## **Objection to planning application No. 3/2023/0261**

**Planning Application Reference No.:** 3/2023/0261

**Address of Development:** Brookes House, 8 Brookes Lane, Whalley, BB7 9RG

Drawing Title
Existing Garage Floor Plans and Elevations

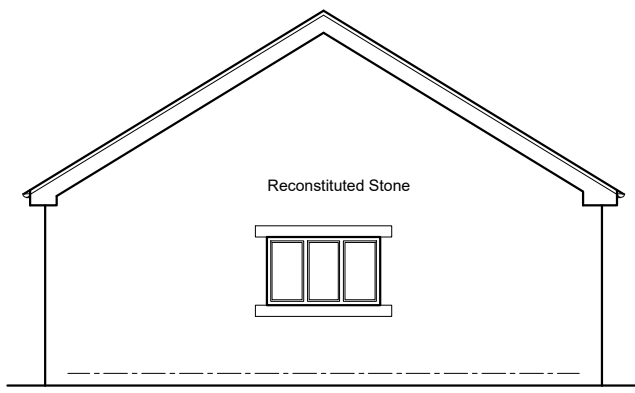
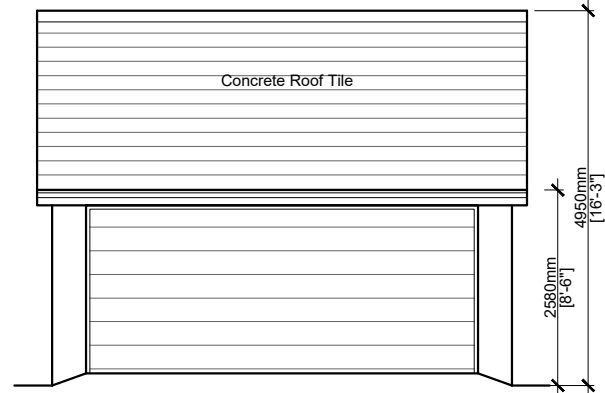
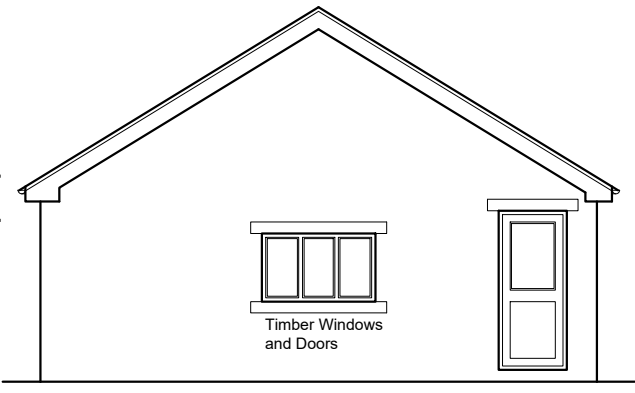
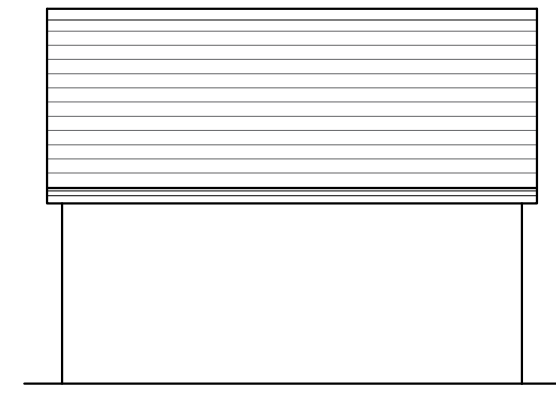
- ' This proposal is designed to facilitate a bespoke dwelling to assist with downsizing and future needs' The applicant [REDACTED]
- The plan of the existing garage is inaccurate, it shows no window on the east facing elevation. Whilst this does not impact on the proposal it is further evidence of inaccurate information contained in the application.

PROPOSED SOUTH ELEVATION SCALE 1:50

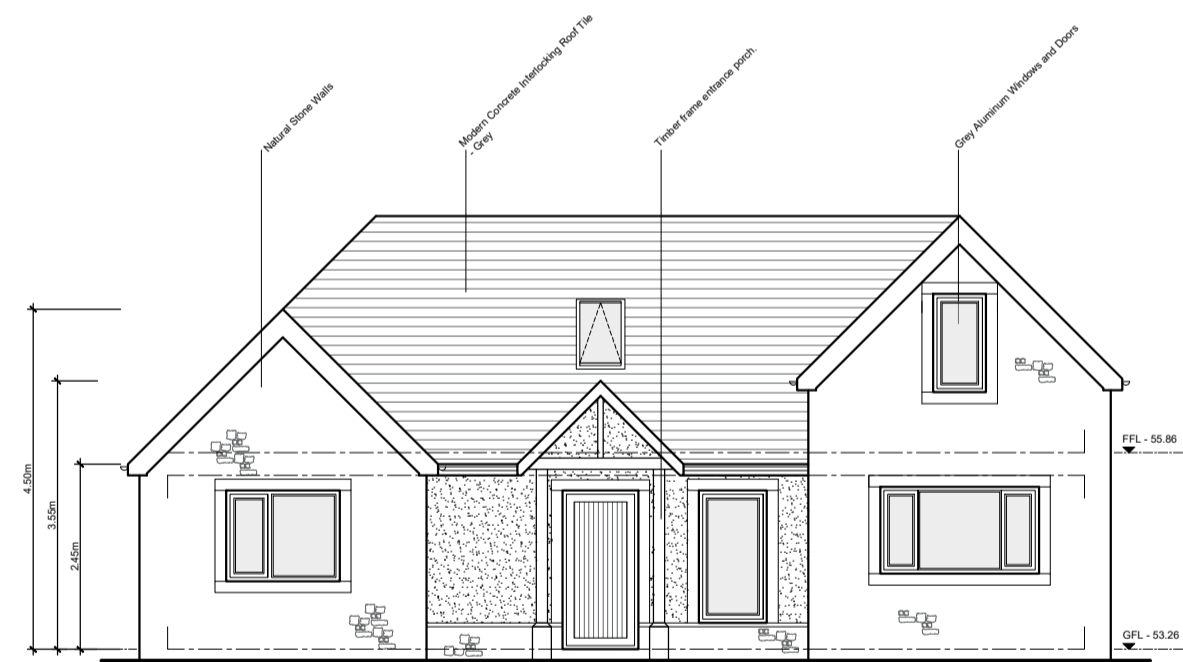
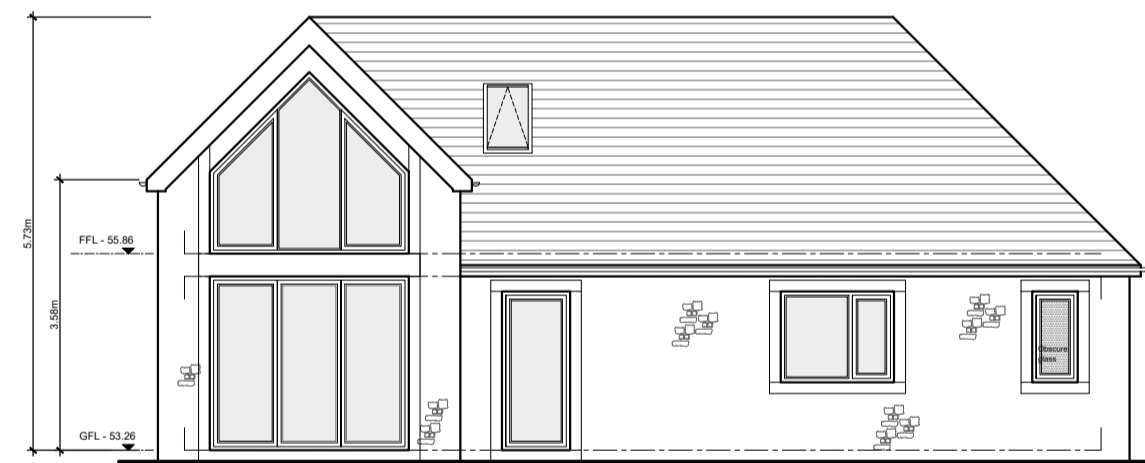
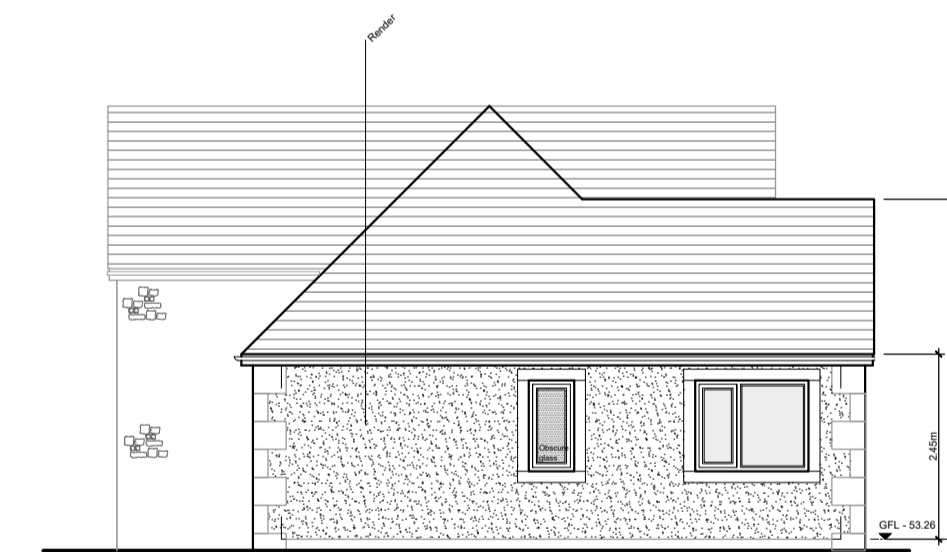
The proposed plans include a two floor glazed gable end on the south elevation, this [REDACTED]

The application states that 'consideration has been provided to surrounding properties by introducing obscure glazing at first floor on the front elevation, all other windows will have little impact on the [REDACTED] This statement is untrue.

The east elevation of the proposal [REDACTED] and the noise pollution from the proximity [REDACTED] for the duration of the building works, detrimental to the [REDACTED]

The application states 'the proposal has been designed to ensure there is no negative impact on the surrounding residential area' again this statement is untrue. Obscure glazing on the front elevation is not in keeping with the character of surrounding properties.

We note that obscure glazing is planned for the front elevation of the building, this would be totally out of keeping with the surrounding buildings and again would impact significantly on the vistas in this conservation area.
